## Heritage Submission

SSD Stage 1 Application

InterContinental Hotel

Former Treasury Buildings and Transport House

WEST ELEVATION

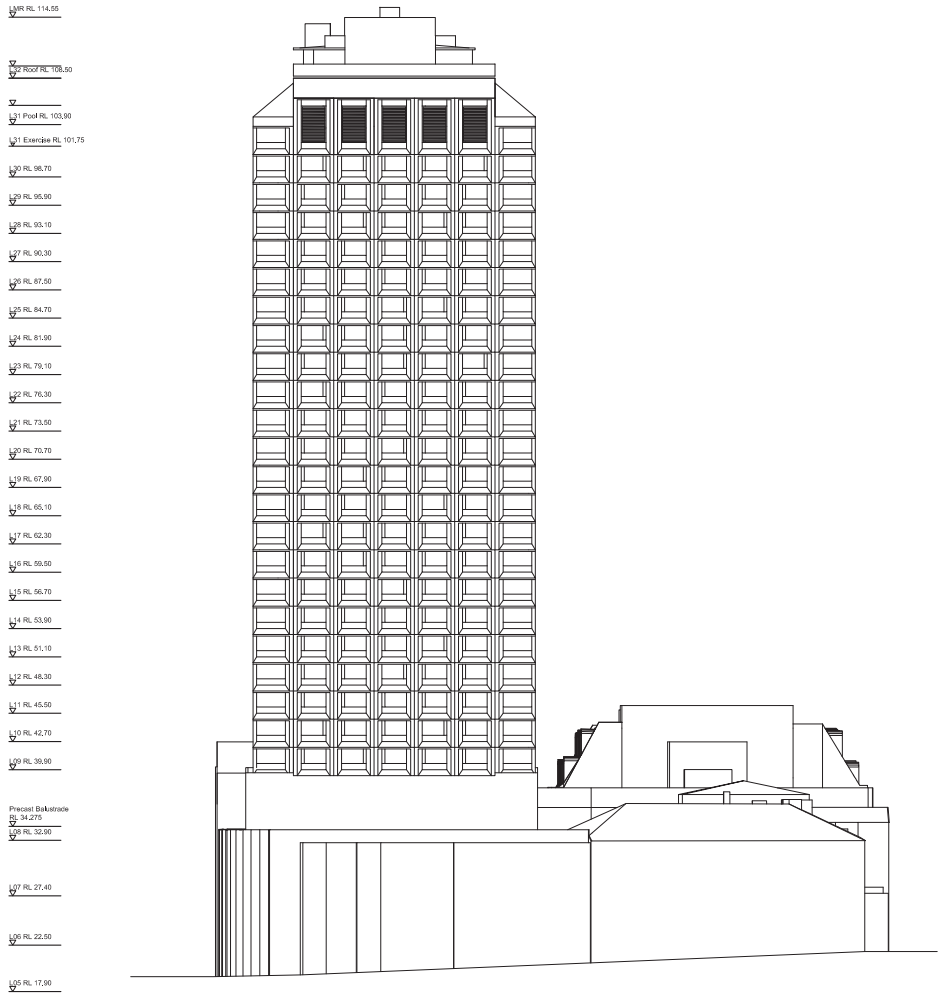
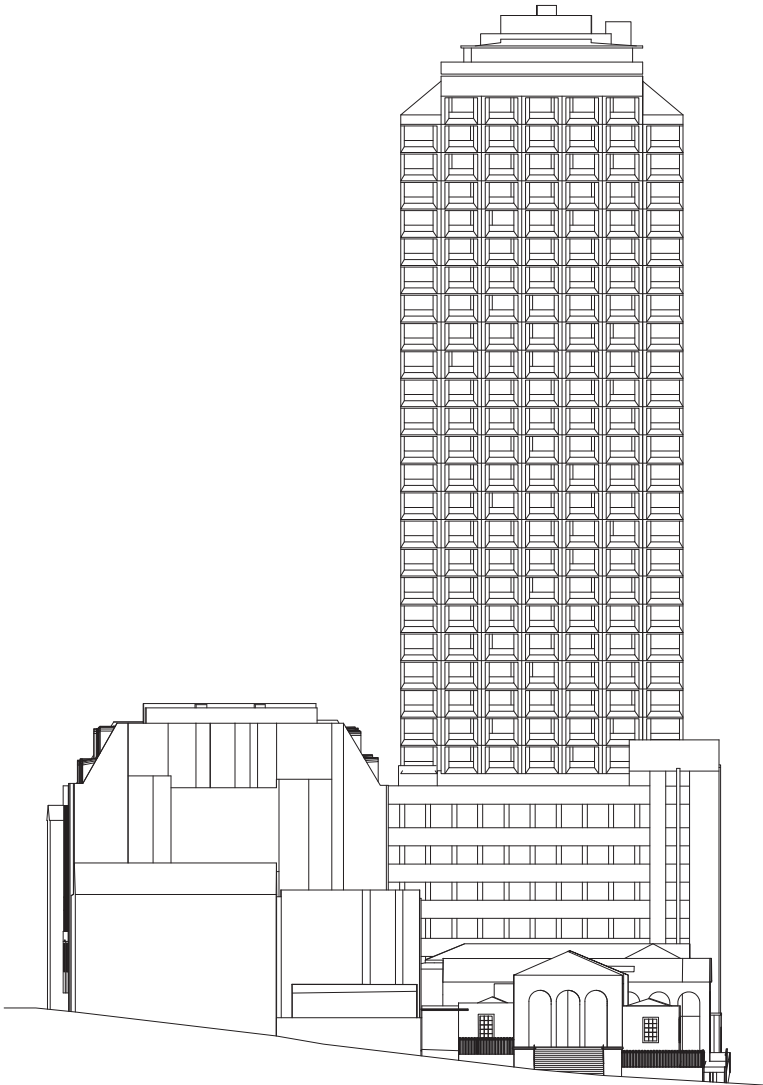
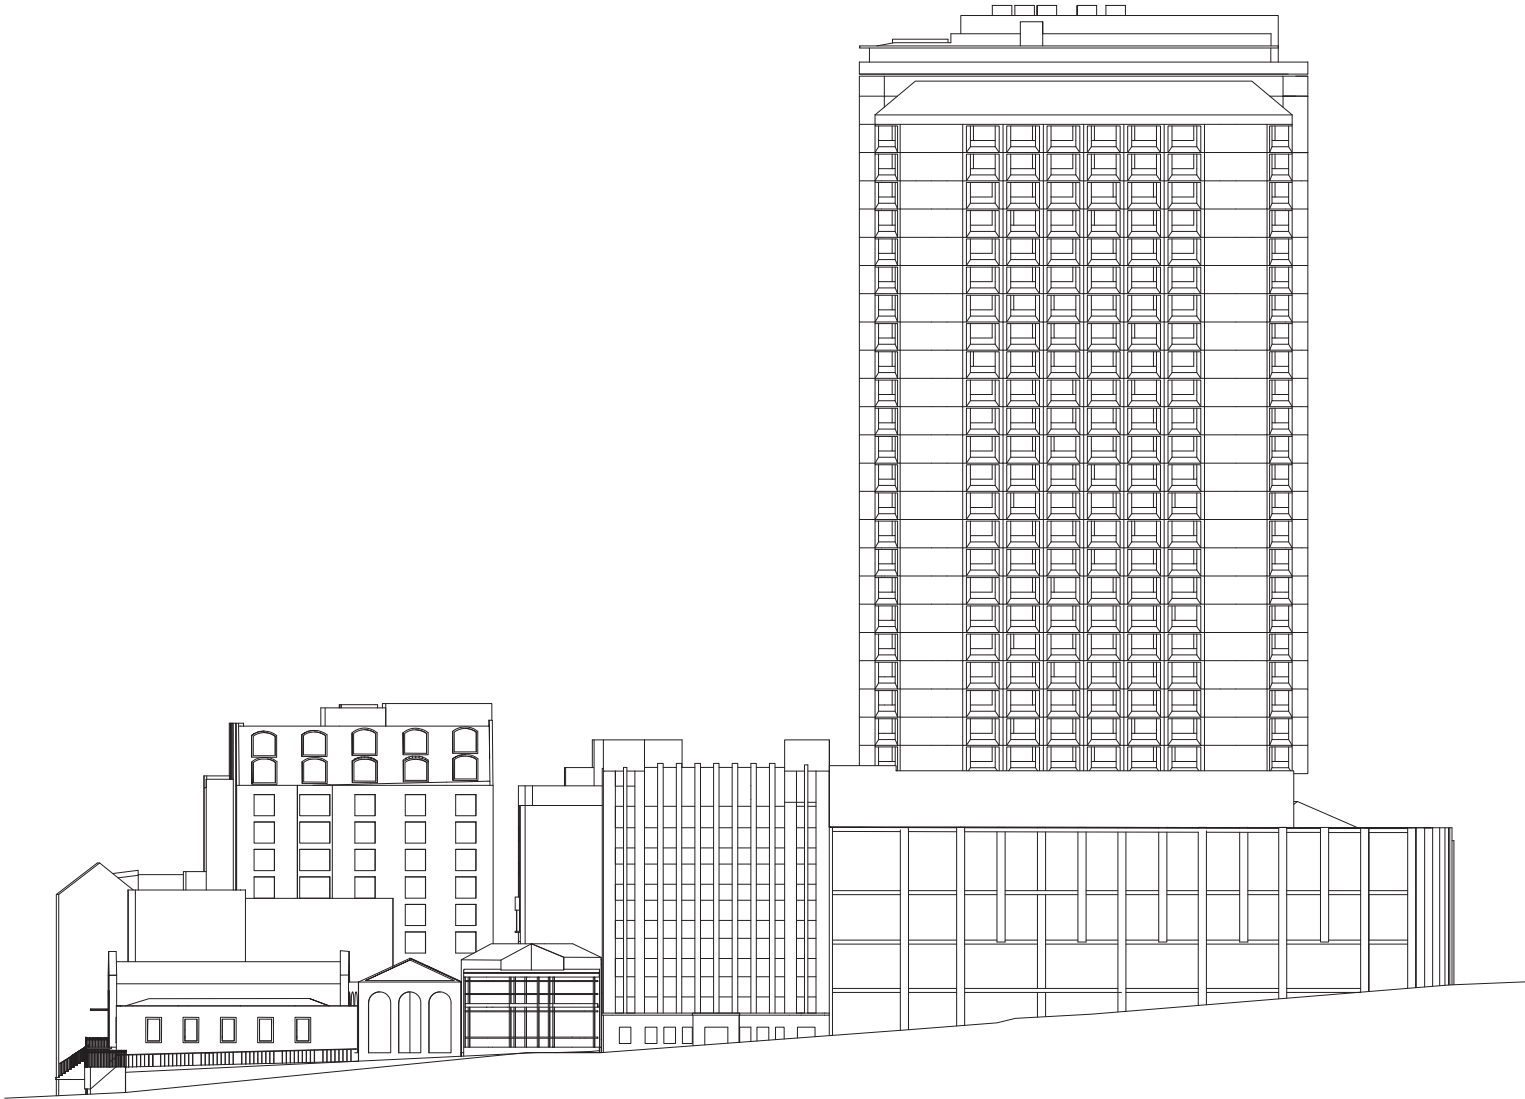
Also at level 8, the plans and elevations show a void space equivalent to a floor over the existing roof, apparently to accommodate the structure of the swimming pool.

The swimming pool is shown at level 9 with a recessed terrace on the north side and the upper level of the new store, hoist and plant room servicing the new pool/ballroom. This structure extends to the northern boundary of the Macquarie Street wing.

The ballroom is located at level 10 with the space extending up to levels 11 and 12. The plans show a service corridor on the west side which appears to sit on top of the two turrets of Transport House, which are an important design feature.

An integral aspect of the composition of the Phillip Street façade is that it emphatically expresses the top of the building to read as the skyline. The proposed addition flush with the face, and on top of the significant turret elements, would completely negate this important quality of the design.

This policy is highly prescriptive in limiting any roof top addition to two to three storeys in scale above the height of the Phillip Street Towers. This might be viewed as a rather arbitrary policy setting if it were not for the fact that it is tailored to correspond to the proposed additions, which appear to be three storeys above the height of the towers.

SETBACK DIAGRAM | VIEW FROM NORTH-EAST

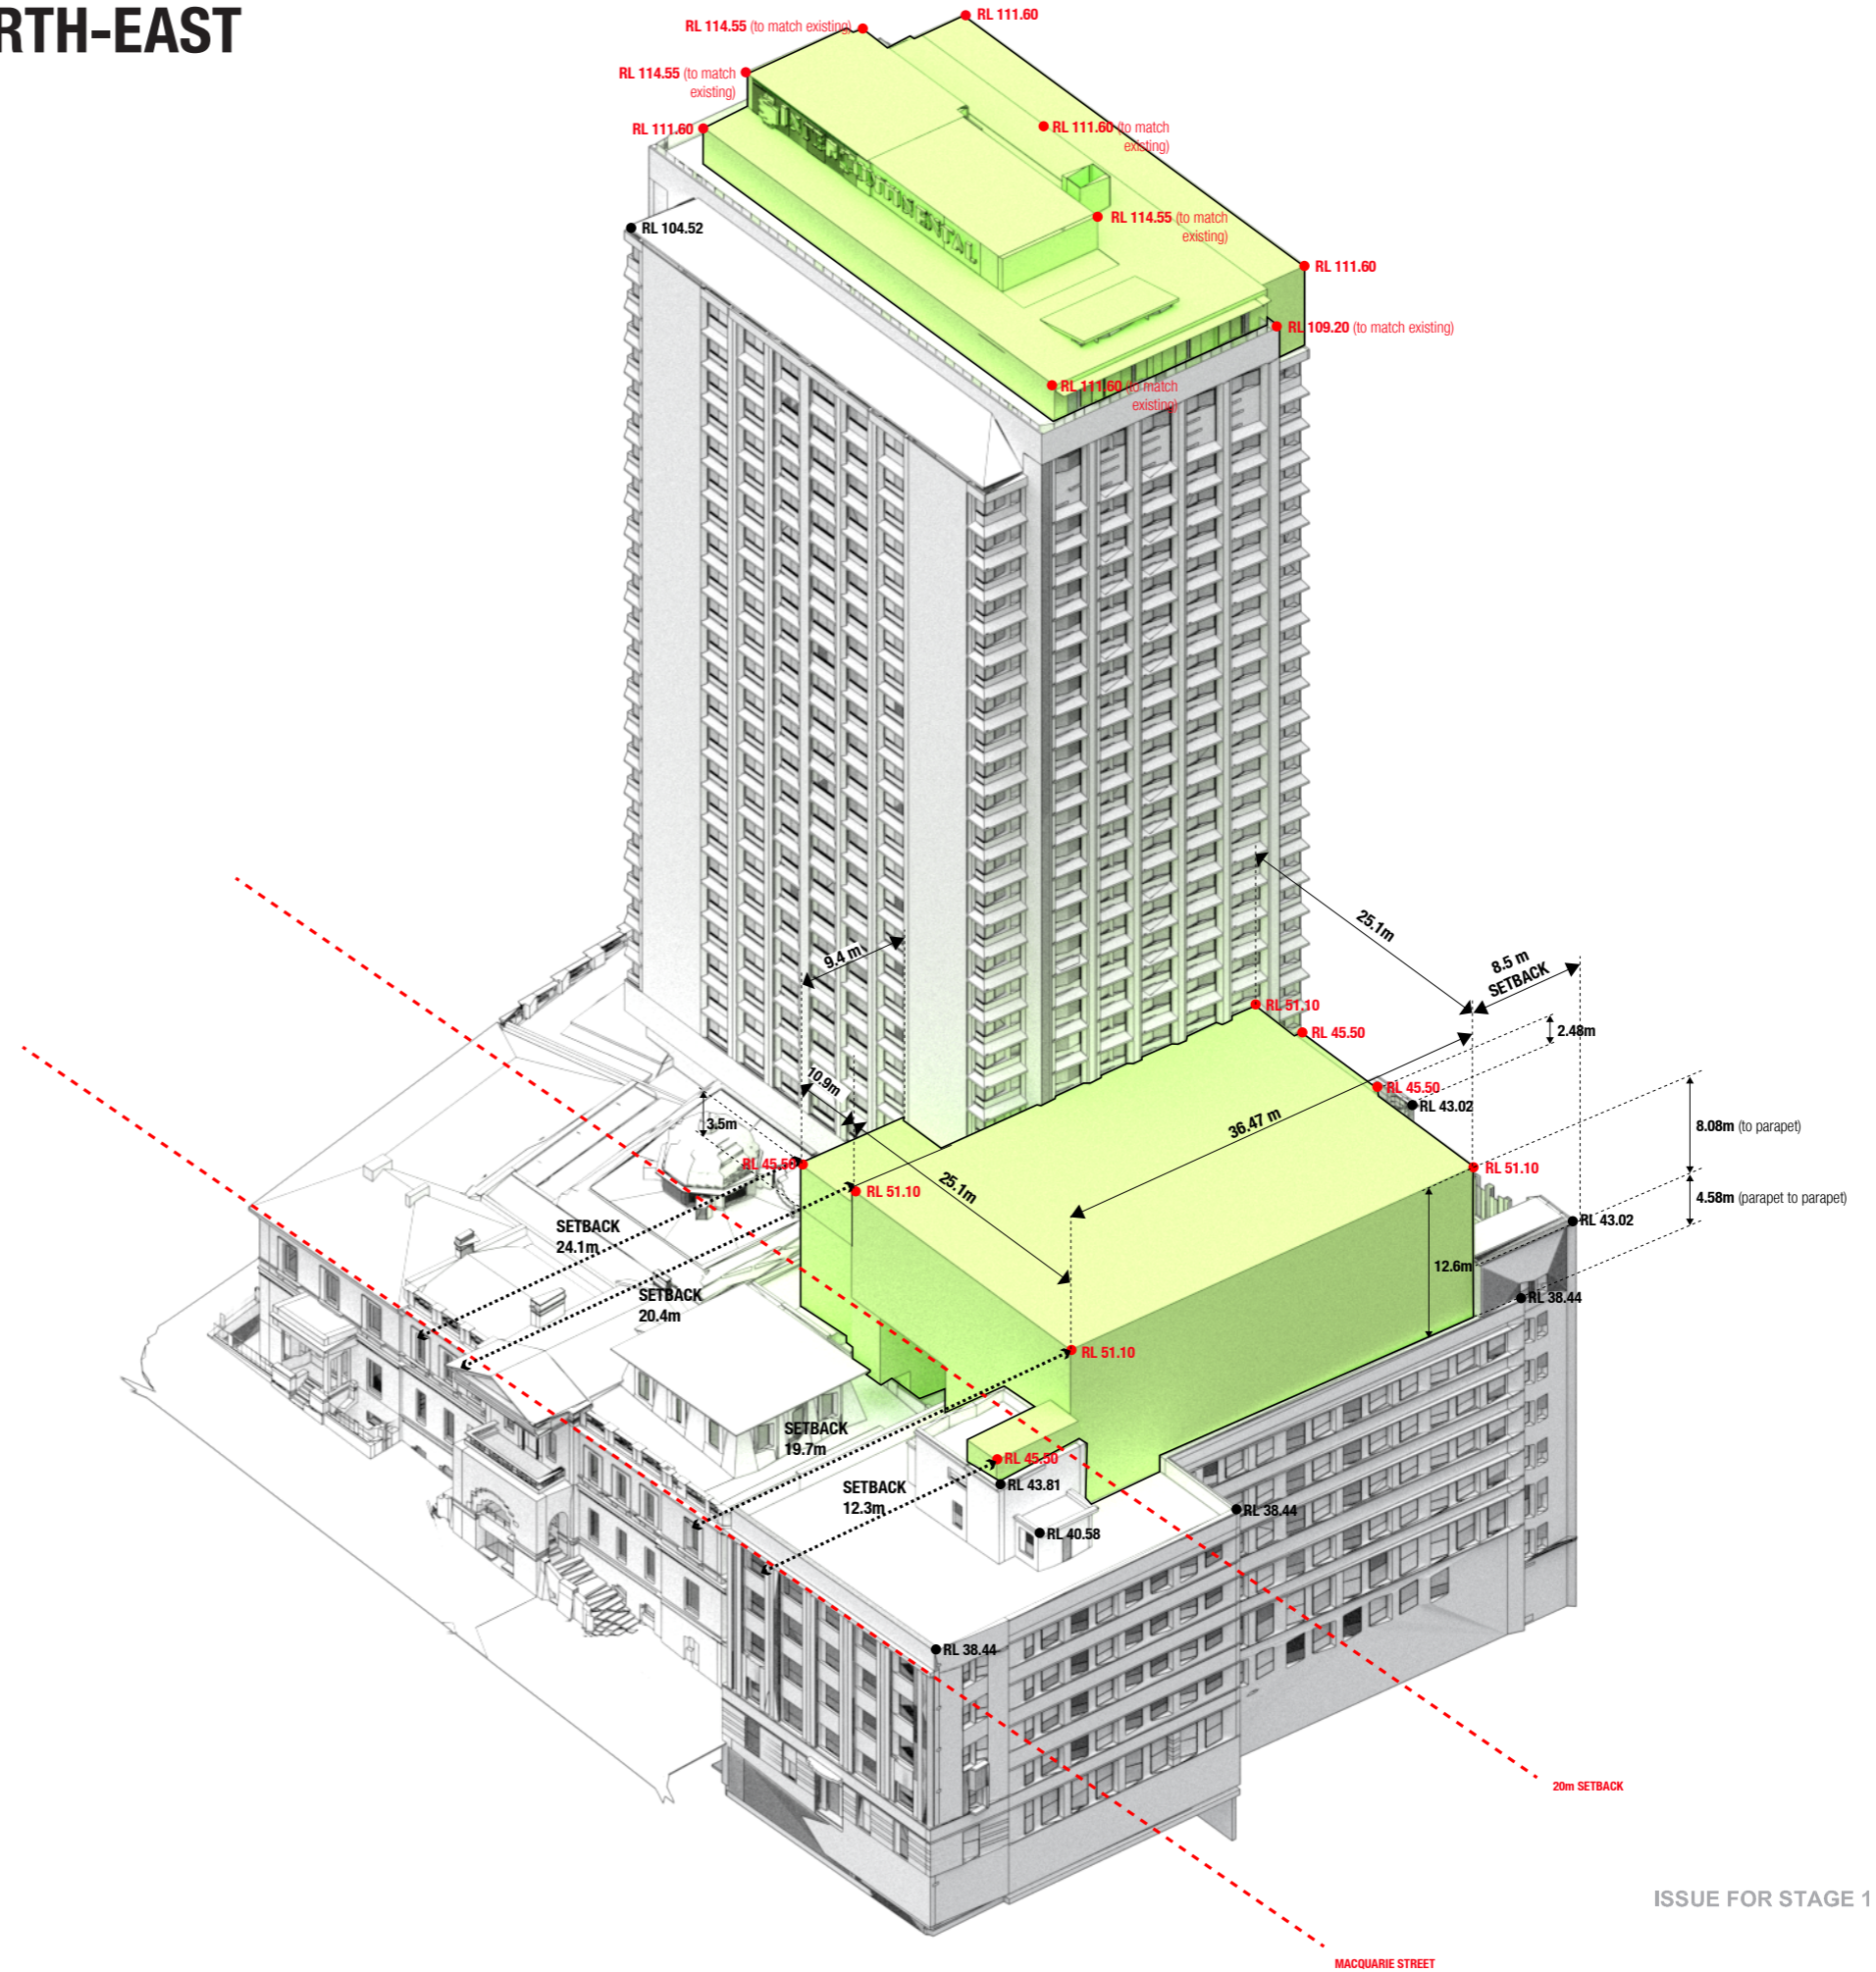
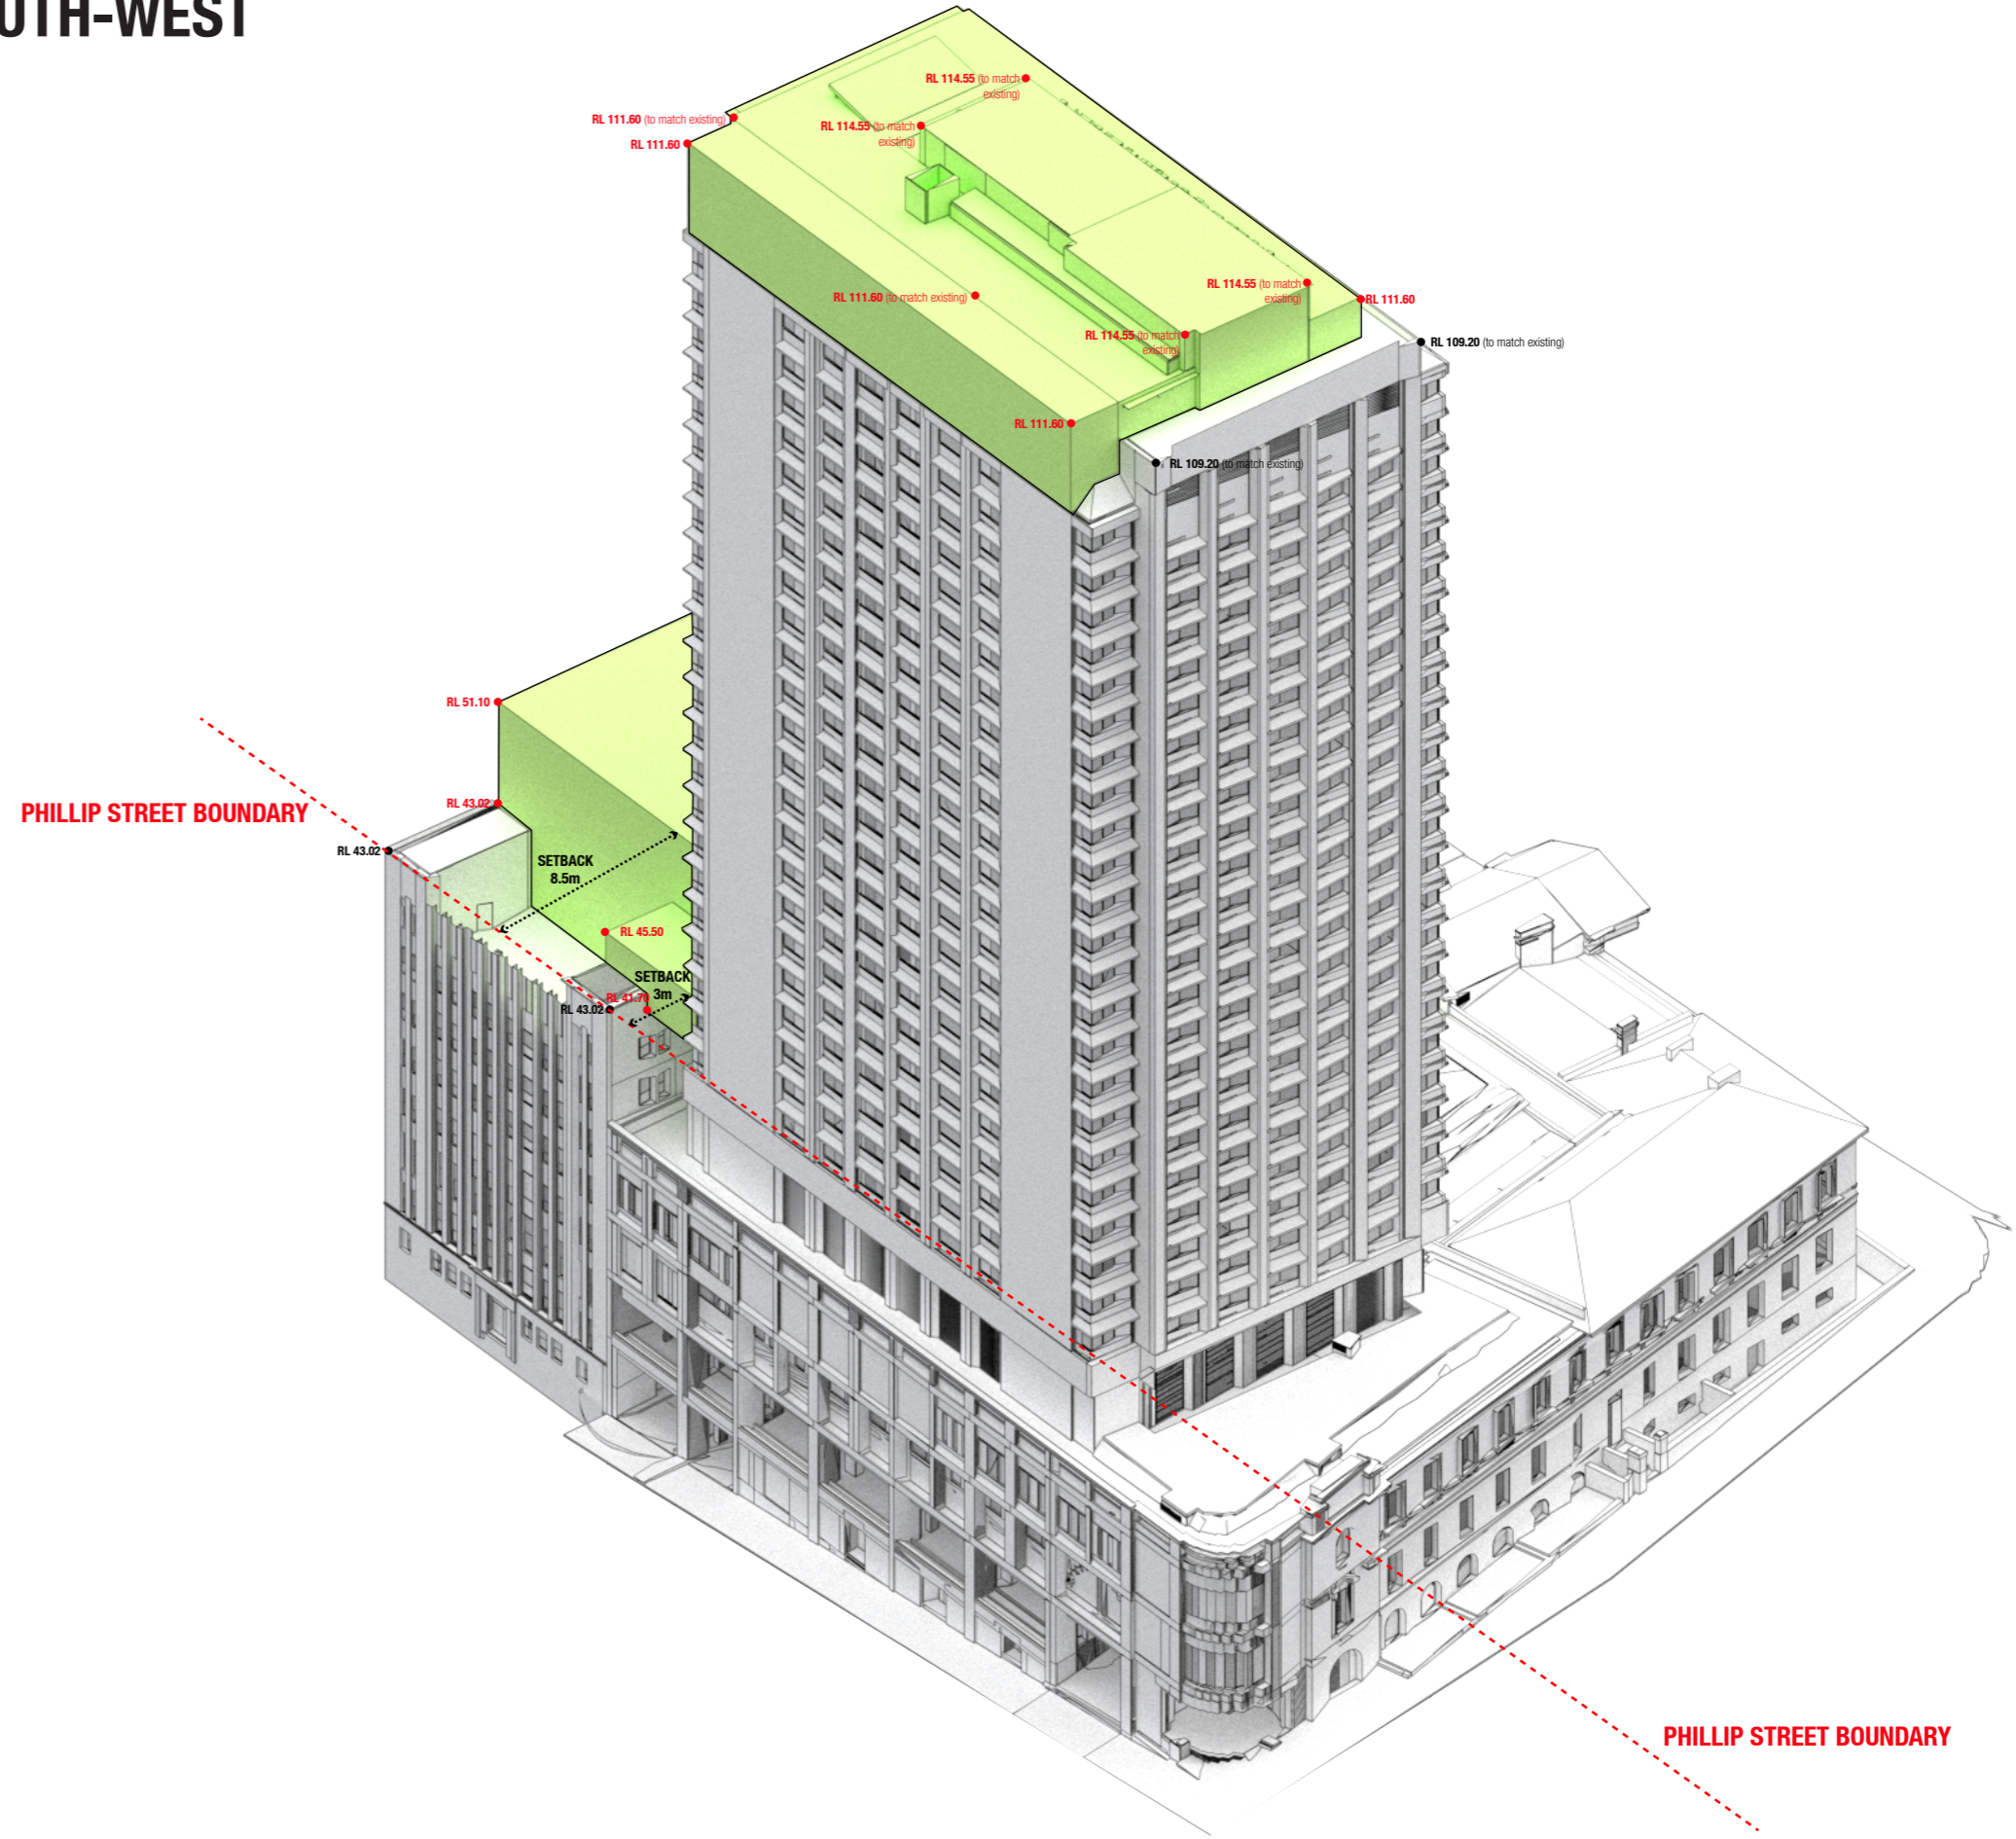
design concept known at the time. The proposed setback from Macquarie Street is in the order of 22 metres. Section 5.1.3 of Sydney Development Control Plan 2012 emphasises the significance of the Macquarie Street Special Character Area by requiring a setback of 30 metres.

The policy does not set a setback from Phillip Street. It does not require new work not to obscure the original form of the Phillip Street parapet and towers as viewed from the public domain and it allows proposed roof top additions not to incorporate setbacks from the Phillip Street façade. This requirement is internally contradictory for the reasons previously discussed. It also fails to take into account Section 5.1.2(3) of Sydney Development Control Plan requiring a 10 metre setback
